Worlington Parish Councils Response to Sunnica's Applicant's Response to Other Parties' Deadline 4 Submissions

TRAFFIC REGULATION MEASURES PLANS -
 TEMPORARY ROAD CLOSURES
 INFRASTRUCTURE PLANNING
 (APPLICATIONS: PRESCRIBED FORMS AND
 PROCEDURE) REGULATIONS 2009 5(2)(O)
 SHEET 13 OF 22

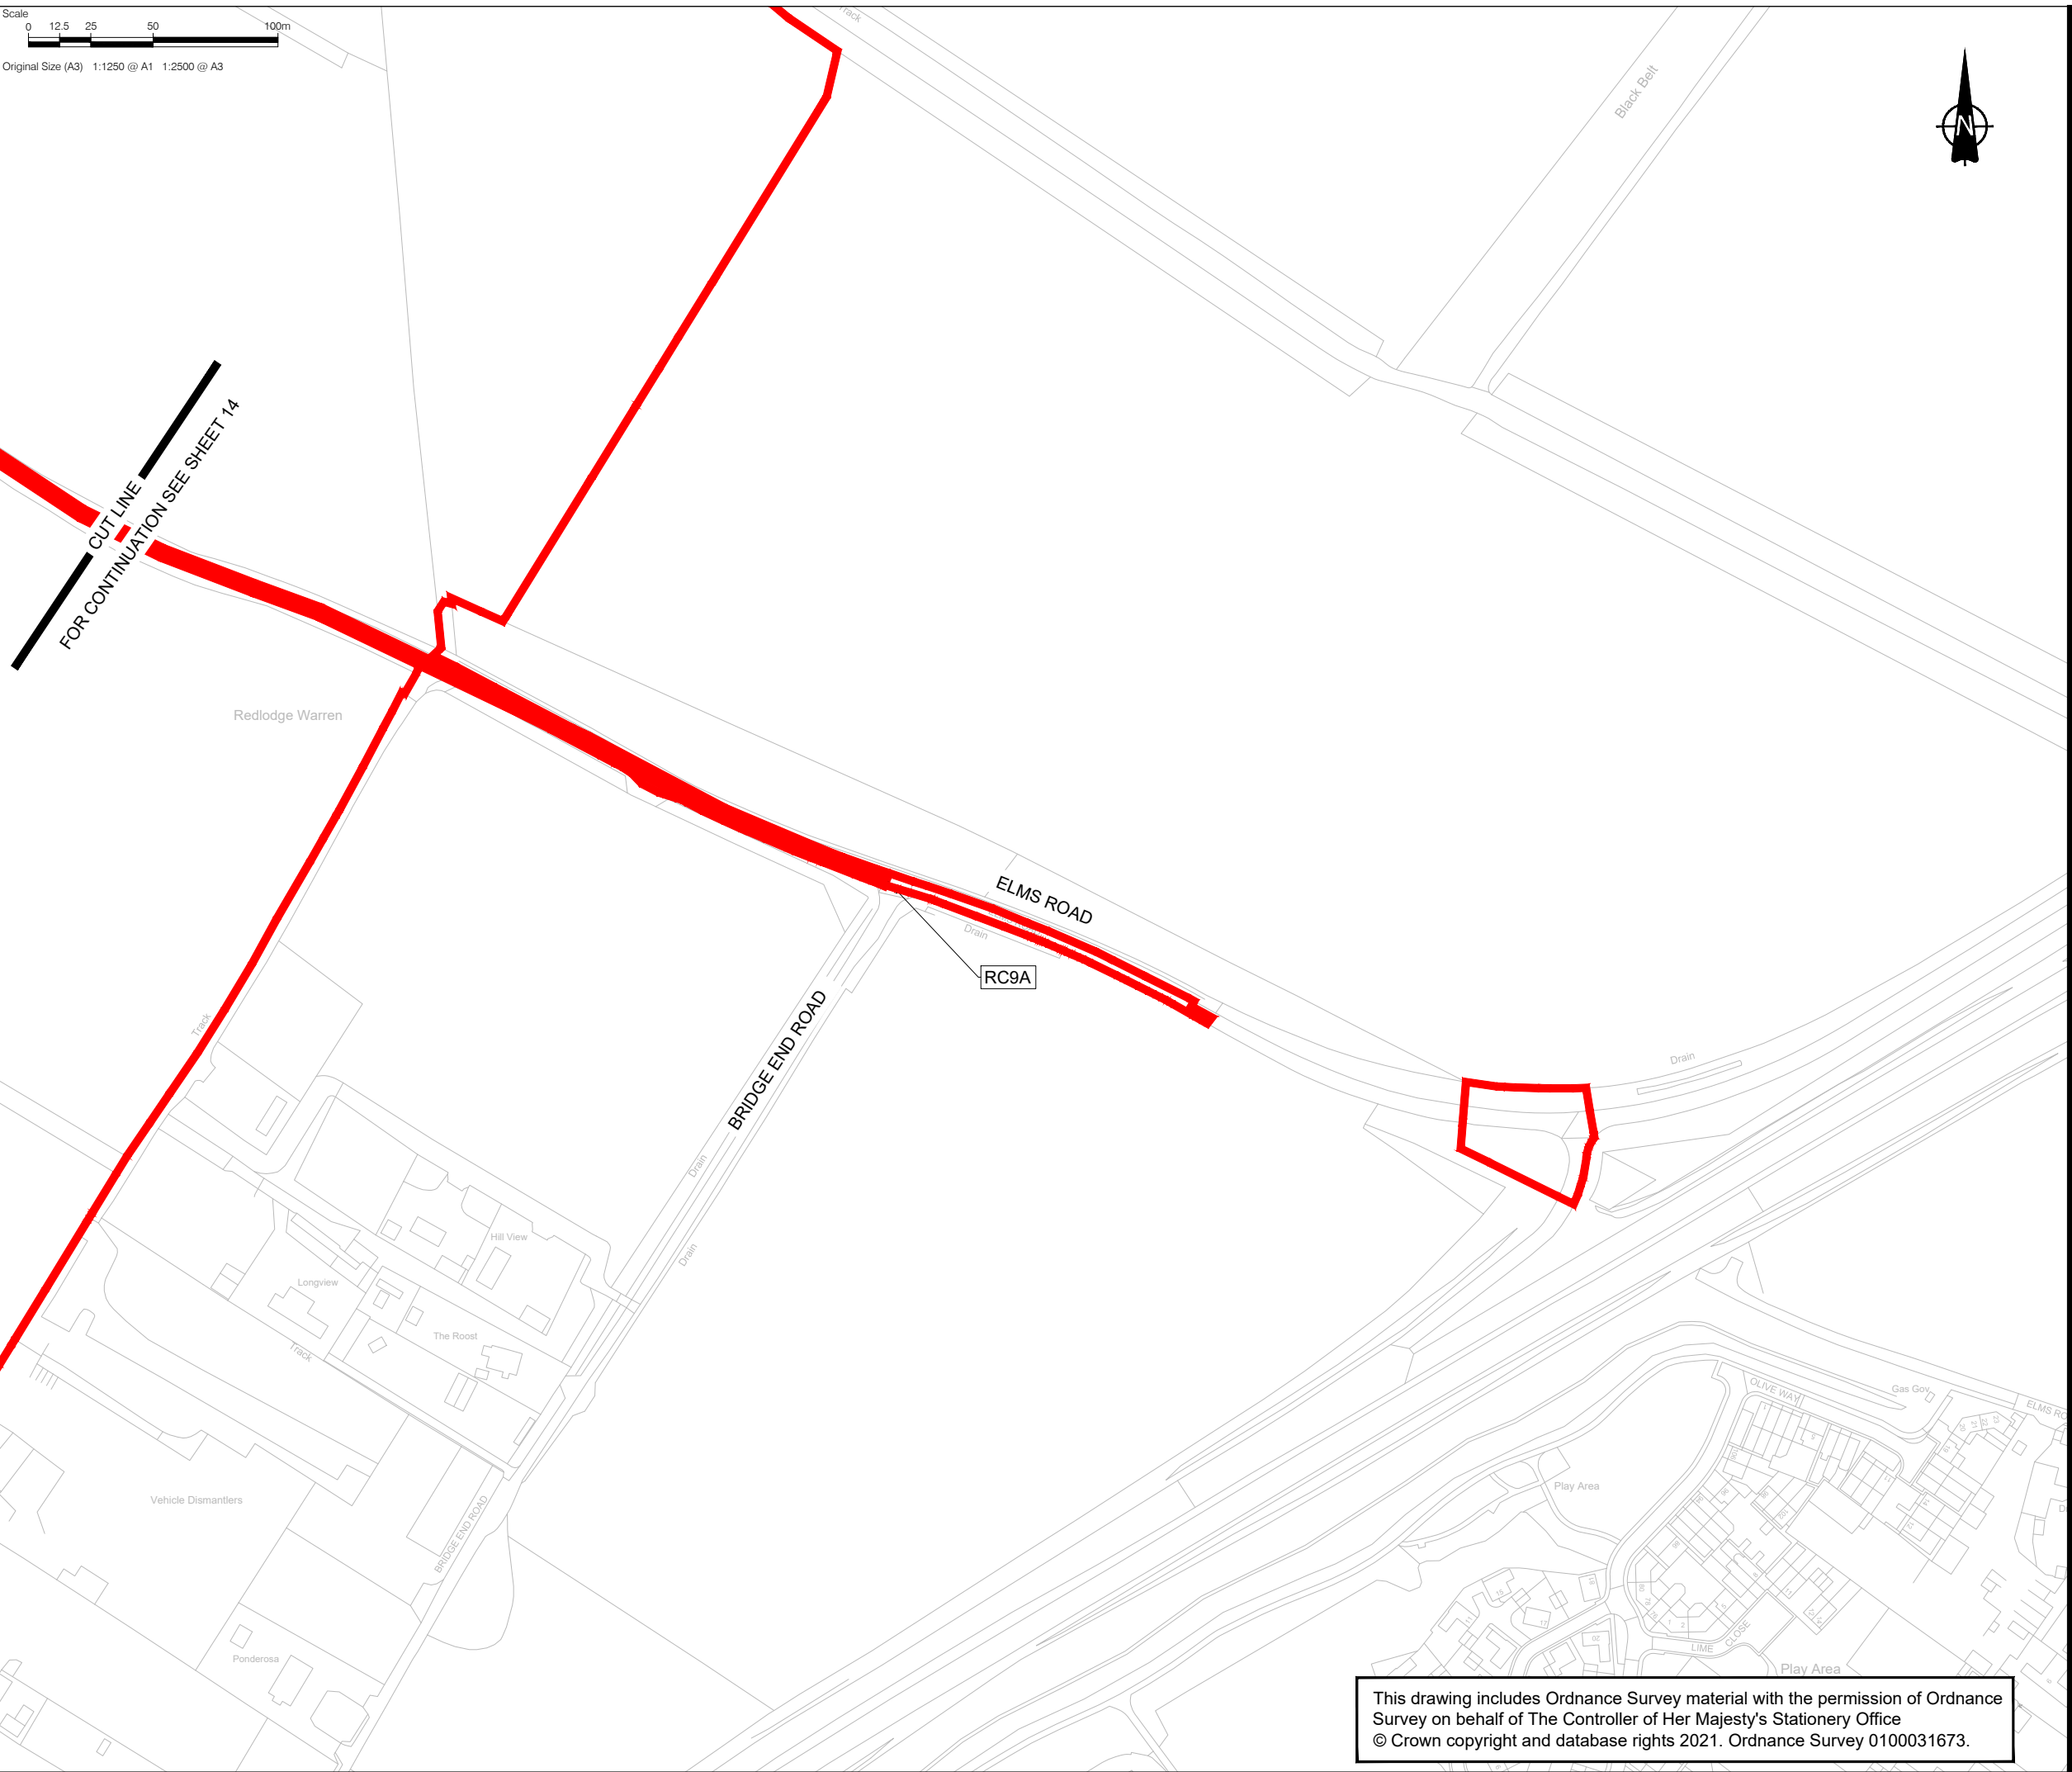
U6006	<p>The DCO under Temporary Road Closures says U6006 will be 'closed to all traffic save under the direction of the undertaker' 450m from the Worlington end for 70m, and 700m from the Freckenham end for 400m to enable cabling and other road works [1]. The small section in the middle of the lane can't be accessed, so effectively the lane will be closed completely as it will not be a through route. I therefore struggle to accept temporary works of three weeks will apply, it seems more likely to be closed for the entire 24 months of construction.</p>	<p>Mr Leitch's concerns are noted but the Applicant confirms that it will not close the U6006 for the entire period of construction.</p> <p>Construction works in this location are for the installation of medium voltage cables that will connect between the inverters in field E12 to E18 and from E24 to 32.</p> <p>There is also a requirement to construct and access road perpendicular to the U6006 to give access to fields E12.</p> <p>The construction schedule for the construction works (all working days) is:</p> <ul style="list-style-type: none"> <li>1- Break open asphalt (2 days);</li> <li>2- Trench opening by excavator. (2 days);</li> <li>3- Installation of cables. (2 days);</li> <li>4- Backfill of trench and resurface asphalt. (2 days);</li> <li>5- Public right of way opened for traffic (5 days)</li> <li>6- Inspection of asphalt for defect and repair and make good if need be. (1 day)</li> </ul> <p>On the basis of the above the U6006 will not be closed for any longer than 21 days.</p>	<p>Worlington Parish council would like more clarification in regards to the following points;</p> <p>1, The Applicants Enviromental Statment 6.2 Appendix 13C: Framework Construction Traffic Management Plan and Travel Plan (APP-118) drawing number 60589004_ES_CTMP_003 "HGV inbound route" shows Part if not all (hard to make out on the map) U6006 within the Sunnica East Site B, marked in red.</p> <p>Within the applicants Key this is listed as Indicative Construction Zone 24 months. It is also noted that all site access points are located south of U6006.</p> <p>Referring to the Applicants statement "There is also a requirement to construct and access road perpendicular to the U6006 to give access to fields E12."</p> <p>If this is the case, the footpath will be obstructed for 24 months not the 21 days stated.</p> <p>2, Asphalt. At present U6006 is a dirt track. Worlington Parish council now presume that the perpendicular access road, which we believe to pass through U6006 is to be laid with asphalt.</p> <p>Worlington Parish Council seek clarification.</p> <p>*Will Part of U6006 be accessible but no longer connect the villages of Freckenham and Worlington for 24months.</p> <p>*Will there be a 40+ year site access road crossing U6006.</p> <p>*Will the site access road to E12 be Asphalt.</p>

Drawing file: published-documents / EN010106-001986-SEF_ES_6.3_Figure 12-5 Public Rights of Way Affected During Construction.pdf

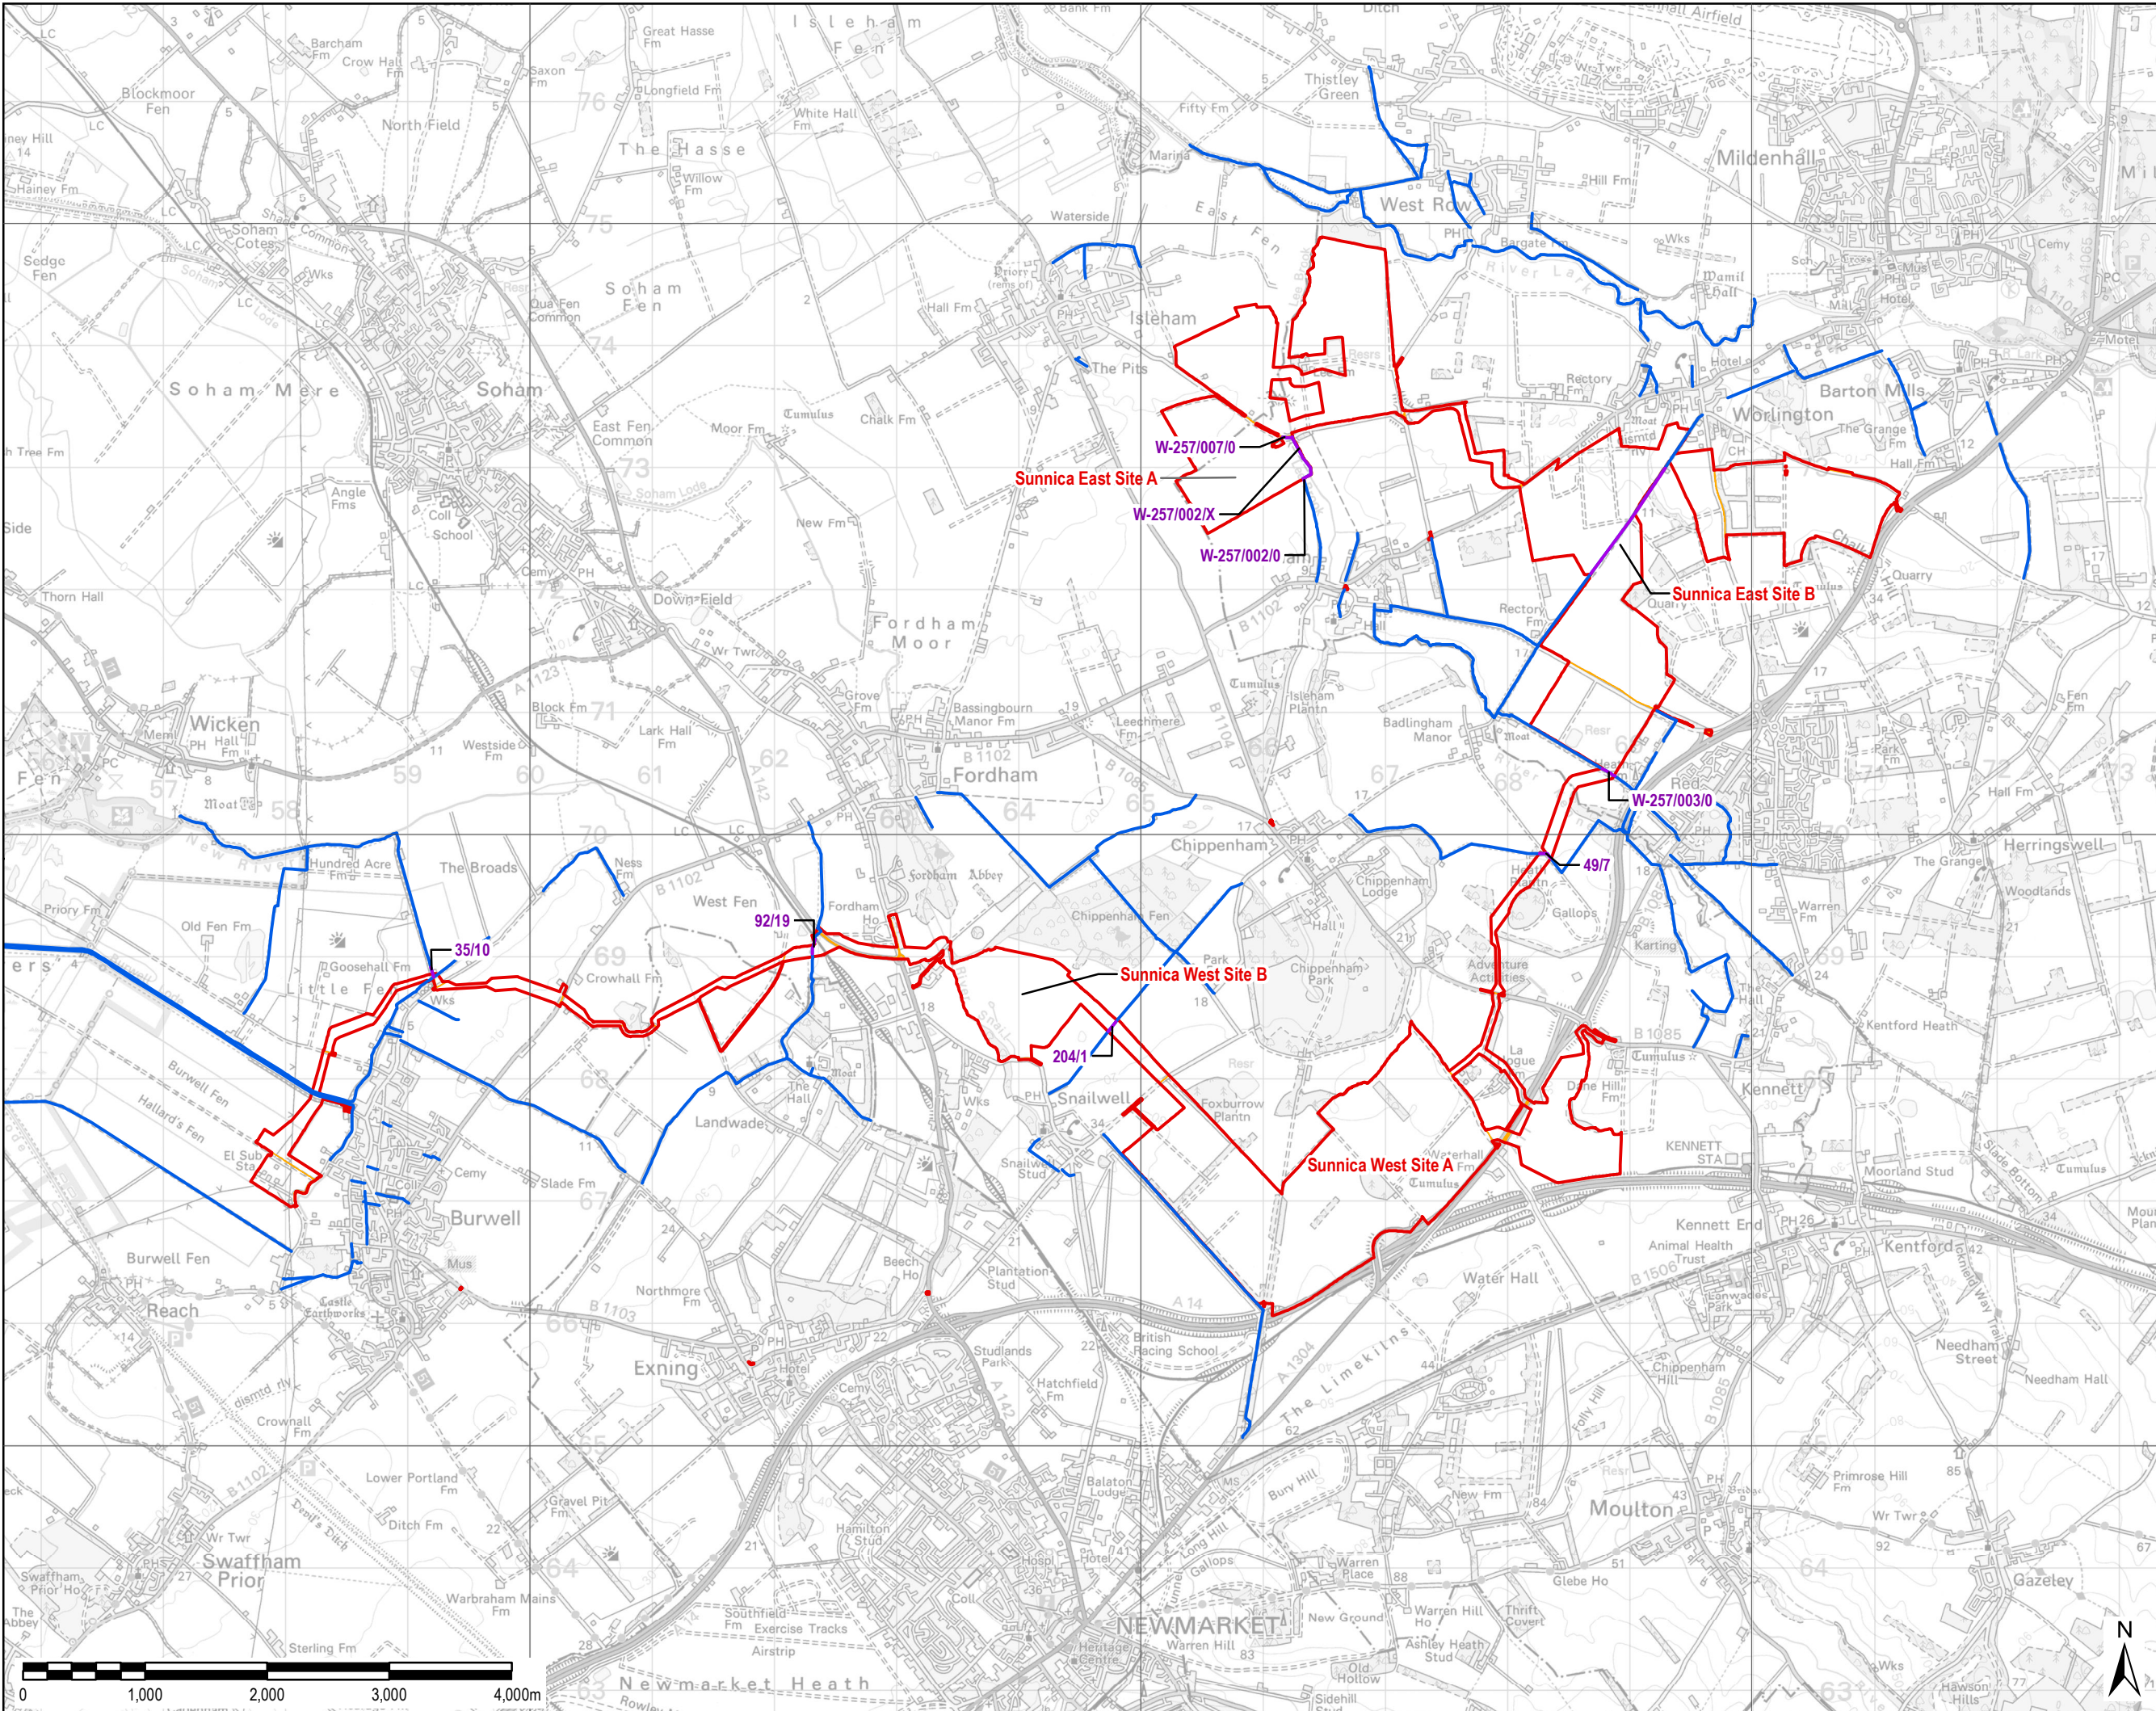
<p>powers contained in the DCO, if granted, in respect of highways. The Applicant looks forward to discussing the Heads of Terms with the local highway authorities in the coming weeks. Furthermore, a note on how PRoW closures will be dealt with has also been submitted at Deadline 5.</p> <p>Badlingham Lane passes between two rows of mature trees and dense vegetation, which enclose much of its length and screen views out to the wider landscape. Visual impacts on users of Badlingham Lane have been assessed in detail in Chapter 10: Landscape and Visual Impact Assessment of the Environmental Statement [APP-042]. Impacts were assessed with reference to four viewpoints (15, 15A, 15B and 16) representing sequential views along the route. Significant effects are predicted in construction and year 1 of operation, reducing to not significant by year 15 of operation, when proposed planting and existing deciduous vegetation would be in leaf.</p> <p>Mitigation of effects on users includes provision of substantial offsets and additional planting, proposed in places along the route to reinforce habitat connectivity and visual screening of solar panels in adjacent fields. Two new permissive routes around Sunnica East Site B are also proposed which will enable enhanced public access for recreation across the landscape. These include a new permissive route adjacent to Elms Road and around the perimeter of E19 and E22 which would link to PRoW U6006 and routes between Red Lodge; and a new permissive path across Sunnica East Site B, to provide access from U6006 across the north of Sunnica East Site B to connect with Golf Links Road.</p> <p>The Outline Landscape and Ecology Management Plan (OLEMP) [latest version submitted at Deadline 5] provides information on the proposed mitigation, including the Landscape Masterplan illustrated in Figure 3 and the Illustrated Cross Section in Figures 8 to 13</p>	<p>12.8.50          “To the north-east of the Site south of Freckenham Road (see Figure 12-6) there will be two new permissive routes intersecting the existing diagonal unclassified bridleway (U6006) (final location is subject to agreement with the landowner), during the operational phase of the scheme. One will create a loop to the western side of U6006, and the other creates a route to the east of U6006 to connect with Golf Links Road. These will provide a safe route for the use of local residents in the area during the operational phase of the Scheme, the impact is medium beneficial which results in a minor beneficial effect. This is not considered significant.”</p> <p>Worlington Parish council on <u>additional</u> PROW during operation:          * We feel crossing Newmarket Road within the 40mph zone where there are no footpaths curb side and set less than 100meters from 60mph zone is not a “safe route” option.          *the statement (final location is subject to agreement with the landowner) gives the impression that the landowner has either not been contacted or is yet in agreement.</p> <p>Paragraph 6.3.10 Framework Construction Traffic Management Plan and Travel Plan.          Worlington Parish council seek further information in regards to references of Paragraph 6.3.10. in regards to U6006.          “vehicles to cross the PRoW ” Will there be a crossing over the U6006 to gain site access?          “case-by-case basis ” Where can I find the information in regards to this case?          “the ES assesses temporary closures, rather than managed crossings ”          “worst-case scenario. ” What is the worst-case scenario in regards for U6006?</p>
